**WELWYN HATFIELD BOROUGH COUNCIL
EXECUTIVE DIRECTOR - PLANNING, PUBLIC PROTECTION AND GOVERNANCE**

Application No: 6/2017/0226/HOUSE
Location: 311 St Albans Road West Hatfield AL10 9RJ
Proposal: Erection of wall and gates to front garden
Officer: Mr M Peacock

6/2017/0226/HOUSE

Client Mr and Mrs Hussain 311 St Albans Road Hatfield	Project New garden wall / gates
Drawing planning	Drg no 757 / 101 Rev
Date 03 / 02 / 17	Scale 1 : 100 @ A3

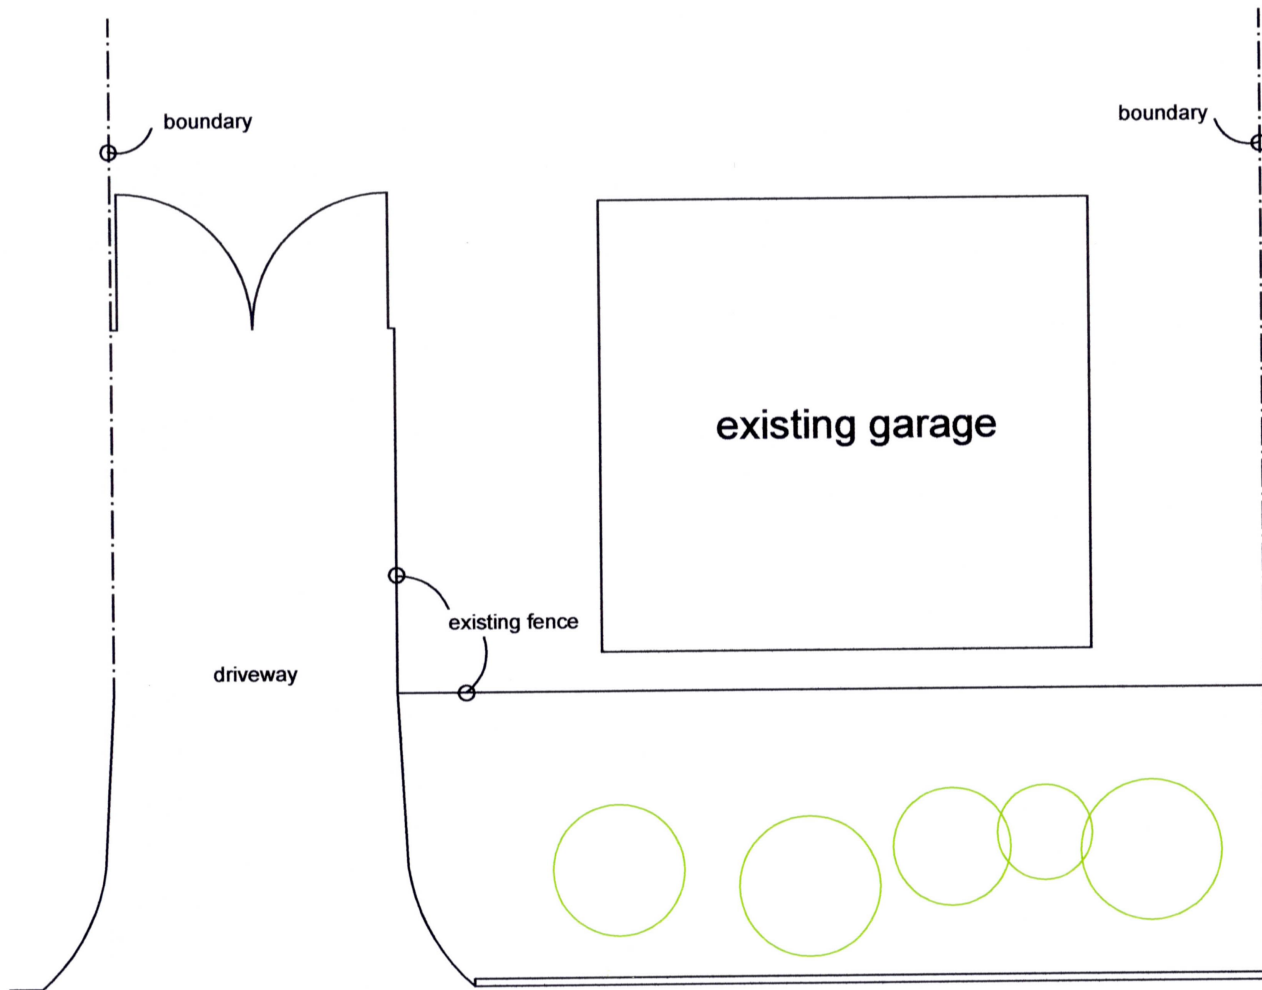
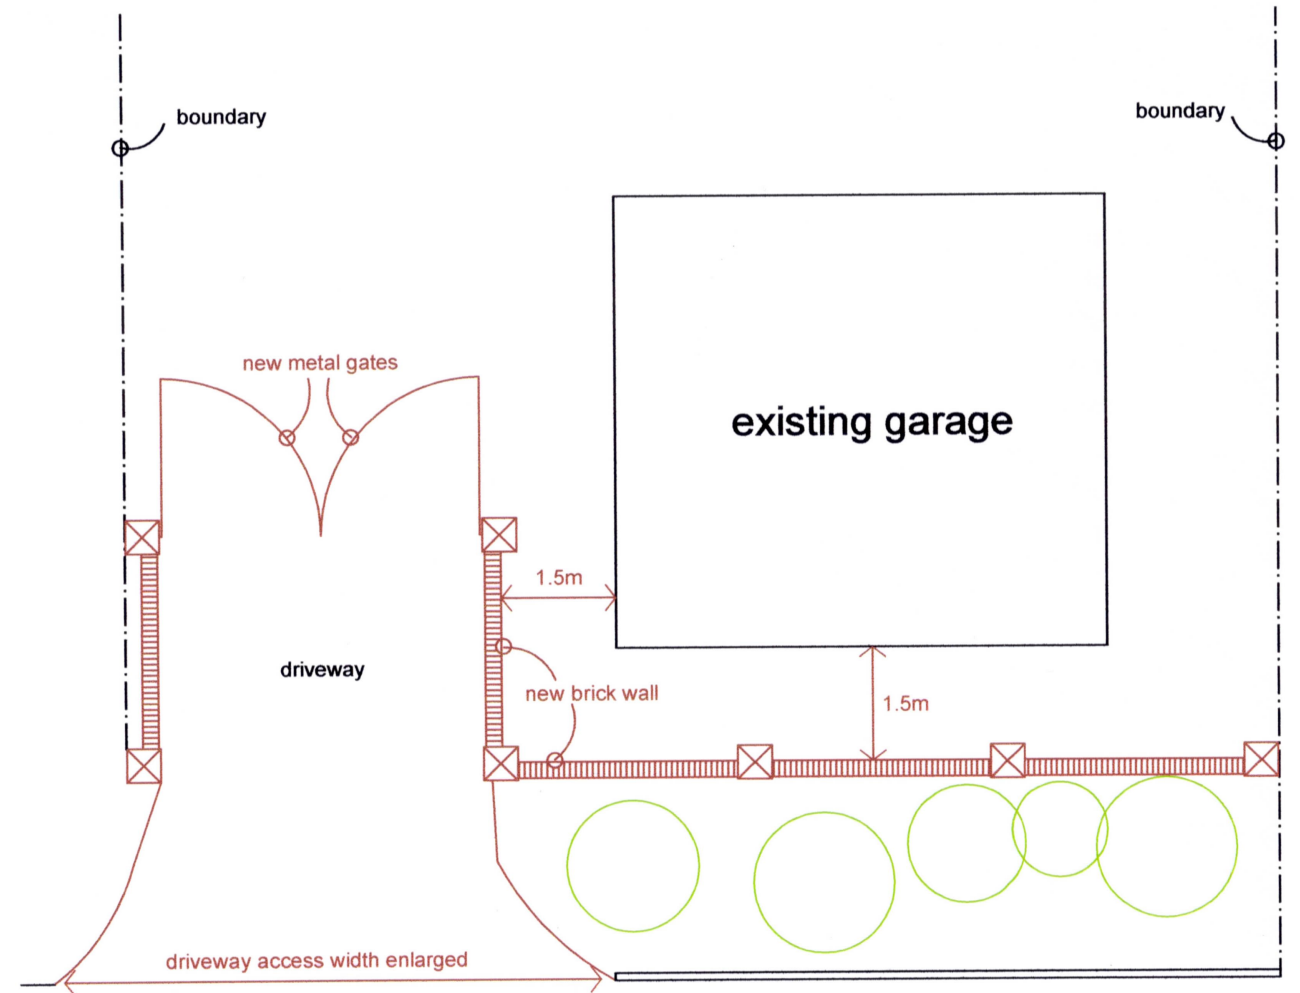
Comment (if applicable): The application dwelling benefits from a double garage close to the front boundary. There is a narrow strip of landscaping along the front boundary. Between the landscaping and the garage is a close boarded fence approximately 1.8m - 2m in height. The access to the site has timber gates of similar height to the fence, which are also solid in appearance. There are other nearby properties fronting onto St Albans Road West which have a similar arrangement in terms of boundary treatment, however, there is variation in terms of design of railings and materials used. The existing landscaping between the hard boundary treatments and the highway is considered to have significant value in terms of visual amenity and the character of the area. Urban trees are also widely acknowledged to have numerous social, economic and environmental benefits. For these reasons a condition is suggested requiring a landscaping scheme to be approved prior to the commencement of development. The scheme shall include protection measures for existing trees as well as planting plans to enhance the existing visual character of the area and to reduce the visual and environmental impacts of the development in accordance with Policies GBSP2, D2 and D8 of the Welwyn Hatfield District Plan 2005.

Whilst the application form indicates that works will be required within the public highway, it is not made clear on either the application form or the submitted drawings whether or not the widening works will be within the public highway or within private land. Should works be required within the highway the widths will be contained to the districts vehicle cross over dimensions policy of 5.4m of dropped kerb. In the interest of highway safety, a condition is suggested requiring details of the proposed access and dropped kerb to be approved prior to the commencement of development. Subject to the approval of details reserved by condition, it is considered unlikely that the proposal will have any material impact on highway safety or capacity.

3. Prior to commencement of development, detailed drawings of all highway works including details of the access arrangements; proposed width of the dropped kerb; and all materials to be used for hard surfaced areas shall be submitted to and approved in writing by the Local Planning Authority. The development must not be carried out other than in accordance with the approved details.

4. The brickwork and mortar of the approved wall must match the existing dwelling/garage in relation to colour and texture.
